Application Ref:	3/2021/0479	 <div>Ribble Valley Borough Council</div> <div>www.ribblevalley.gov.uk</div>	
Date Inspected:	N/A		
Officer:	BT		
DELEGATED ITEM FILE REPORT:		Decision	Refusal

Development Description:	Certificate of Lawfulness for a rear single storey extension.
Site Address/Location:	96 Hacking Drive, Longridge. PR3 3FP

PROPOSED DRAWINGS: PLANS & ELEVATIONS - 003

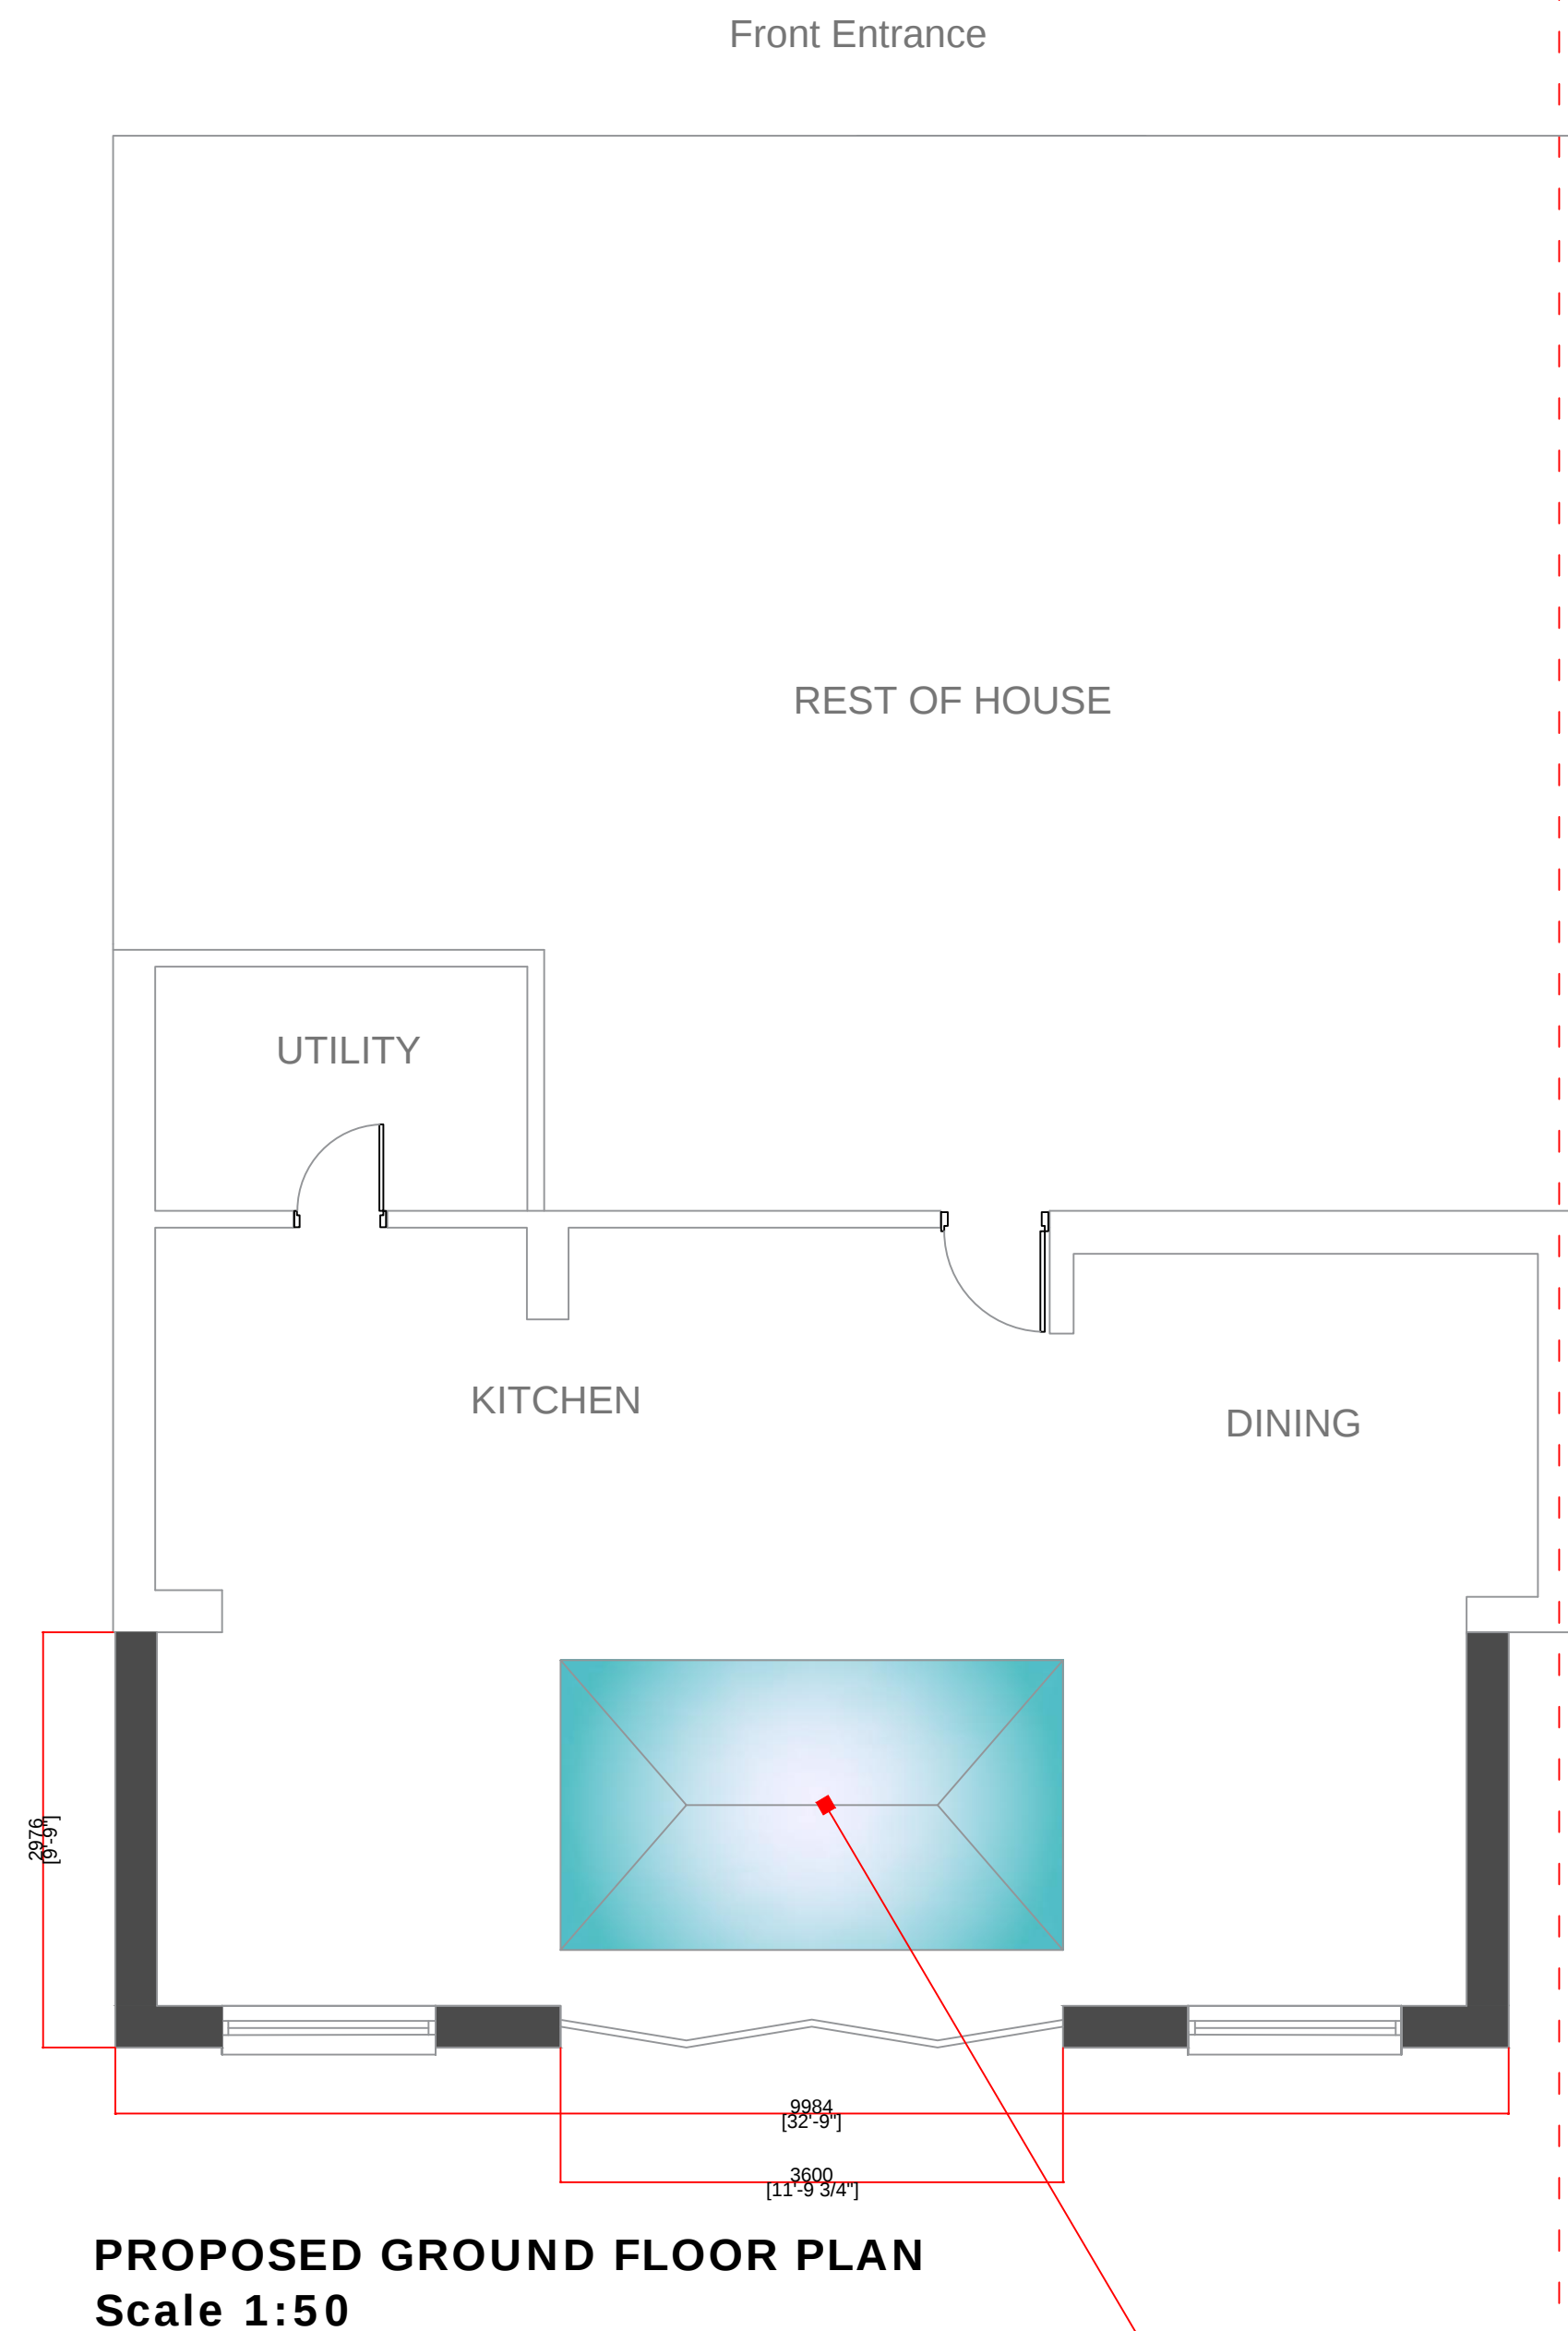
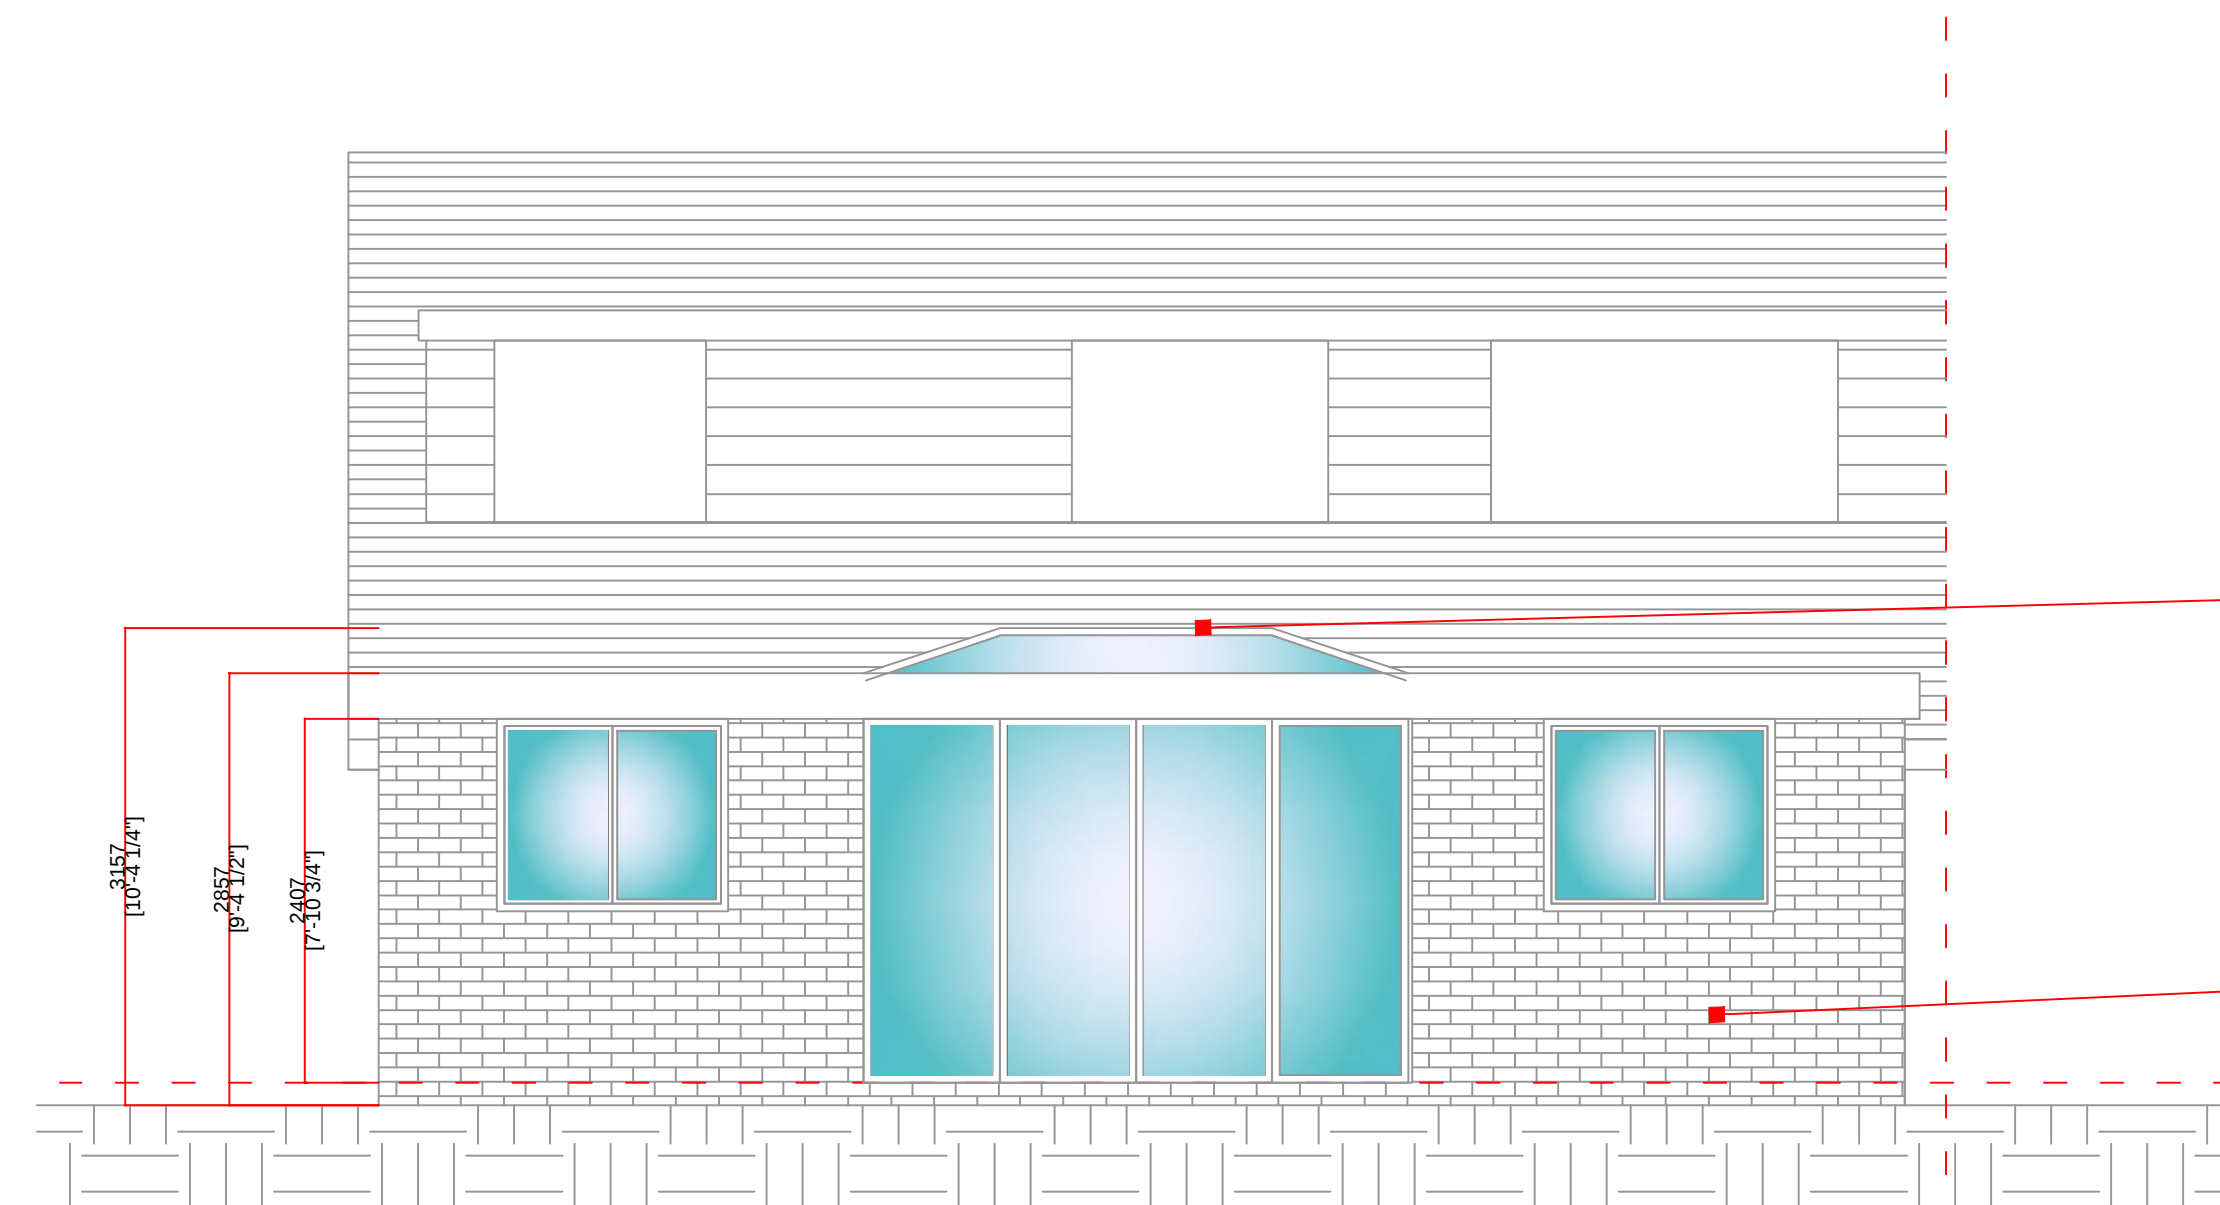
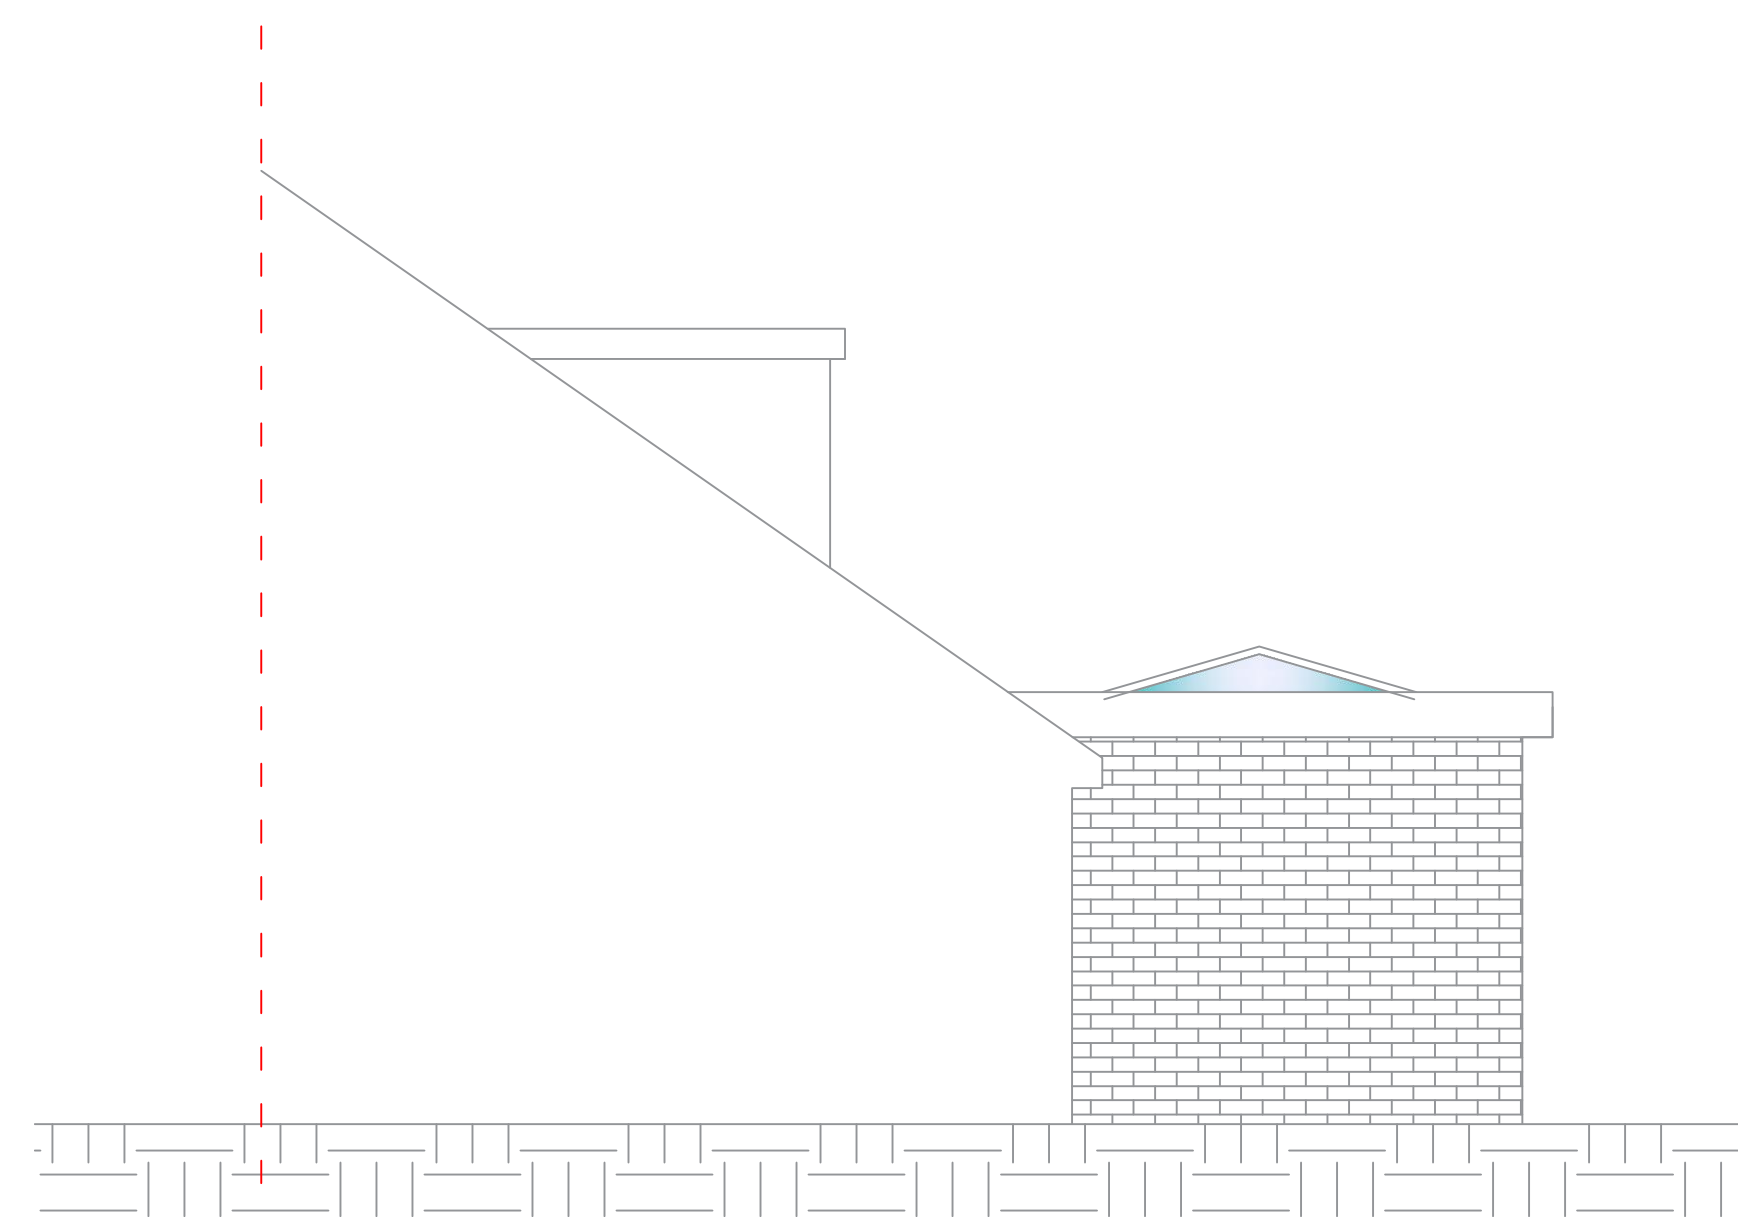
The height of the eaves of the proposed single storey rear extension would exceed the height of the eaves of the existing dwellinghouse by 0.4 metres.

The proposed single storey rear extension would extend beyond the rear wall of the original dwellinghouse by 2.9 metres and measure 3.1 metres in height.

The proposed single storey rear extension would be within 2 metres of the boundary of the curtilage of the dwellinghouse and would be 2.8 metres in height to the eaves measured from the highest part of the surface of the ground adjacent to it.

The proposal is not deemed to be Permitted Development by virtue of Class A, Part 1, Schedule 2 of the Town and Country Planning (General Permitted Development) (Amendment) Order 2015 as the eaves height of the proposed extension would exceed the eaves height of the existing dwellinghouse by 0.4 metres. Accordingly, full planning permission will be required for this particular development.

To refuse the application for a Certificate of Lawfulness.
